Our Ref: STH13/00127/02
Contact: Andrea Boes 4221 2771
Your Ref: MP07_0070 MOD 1

Transport
Roads & Maritime
Services

**WOLLONGONG CITY COUNCIL – MAJOR PROJECT MODIFICATION APPLICATION 07_0070
MOD 1 – 360-364 CROWN STREET, WOLLONGONG – WOLLONGONG PRIVATE HOSPITAL**

TRUE NORTH	Drawn	Checked	Date	Scale
	CQ	HMC	03.06.13	1:500 @ A3
PROJECT NORTH	Drawing Title PLAN - LEVEL 1

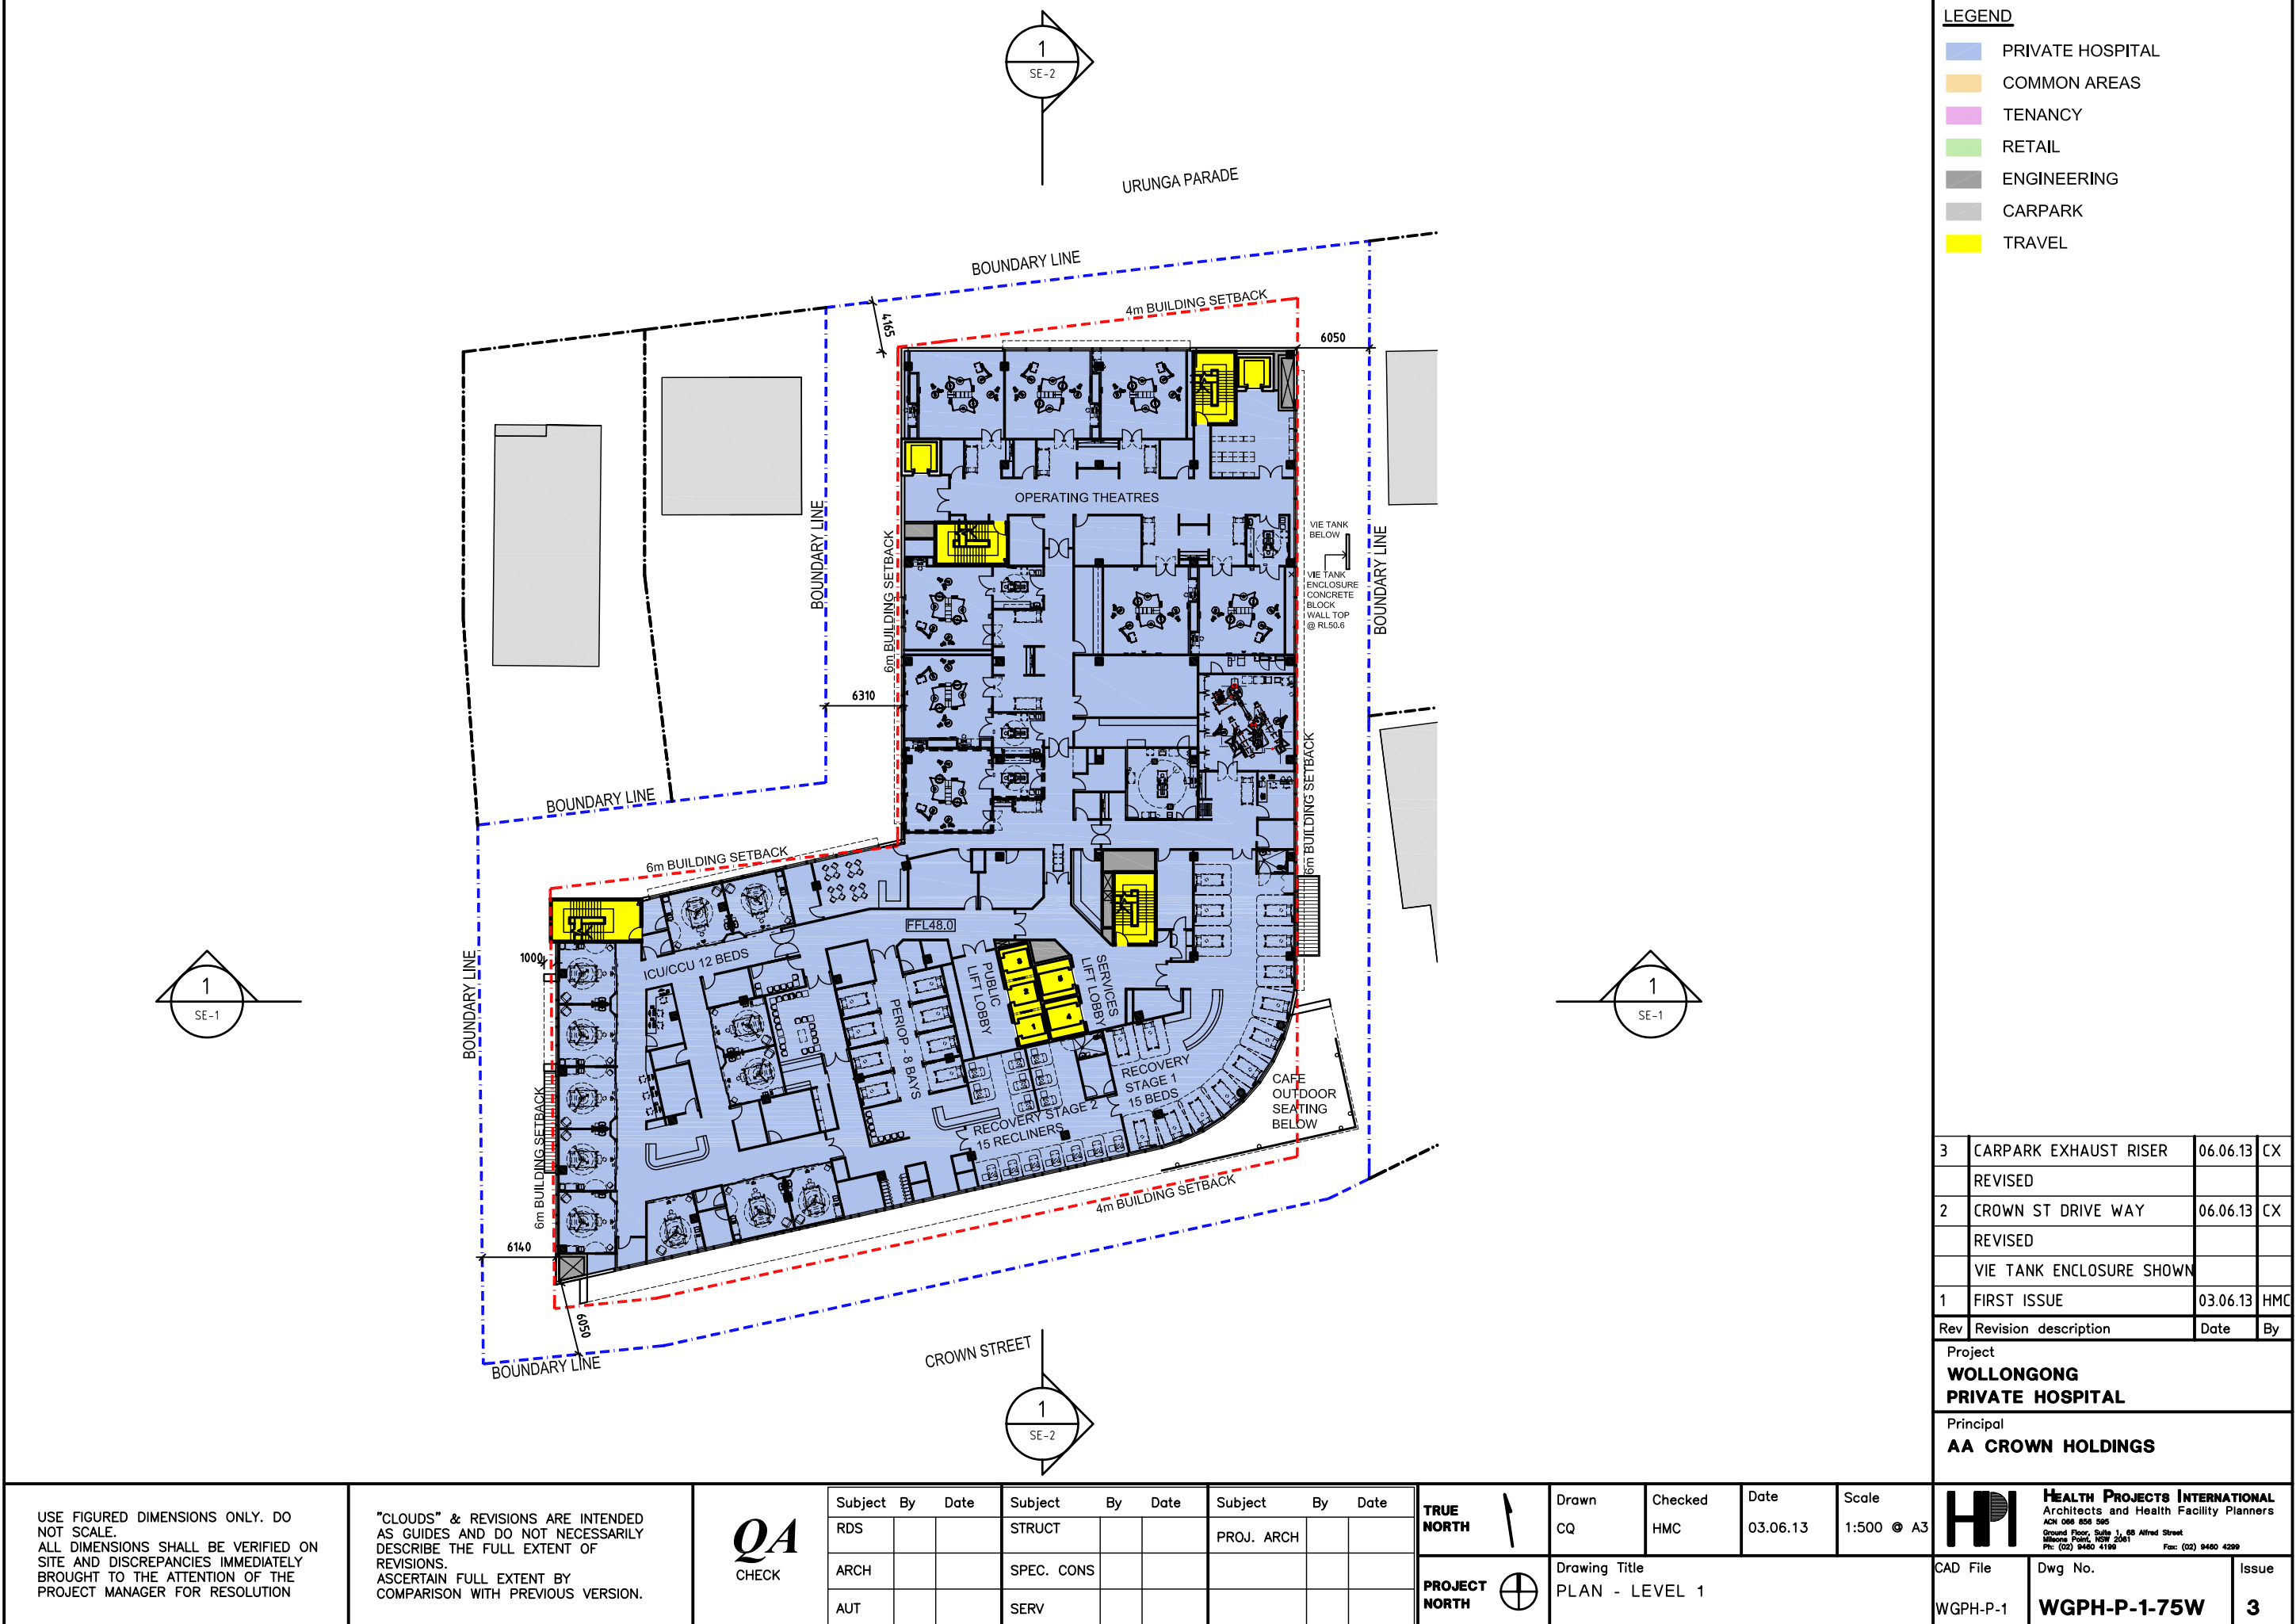
- The existing vehicular access point on the eastern side of the property from Crown Street to Lot 1 DP 565056 shall be physically closed by reinstating the kerb and gutter.

- All ground floor parking, excluding the service yard, shall be marked for accessible and/or staff parking only to reduce congestion and queuing in this area caused by short term parking for general visitors.

- 'Keep Clear' road marking shall be used to ensure that vehicles entering the site to access the underground car park are not obstructed by vehicles waiting to drop off or pick up from the main hospital entry.
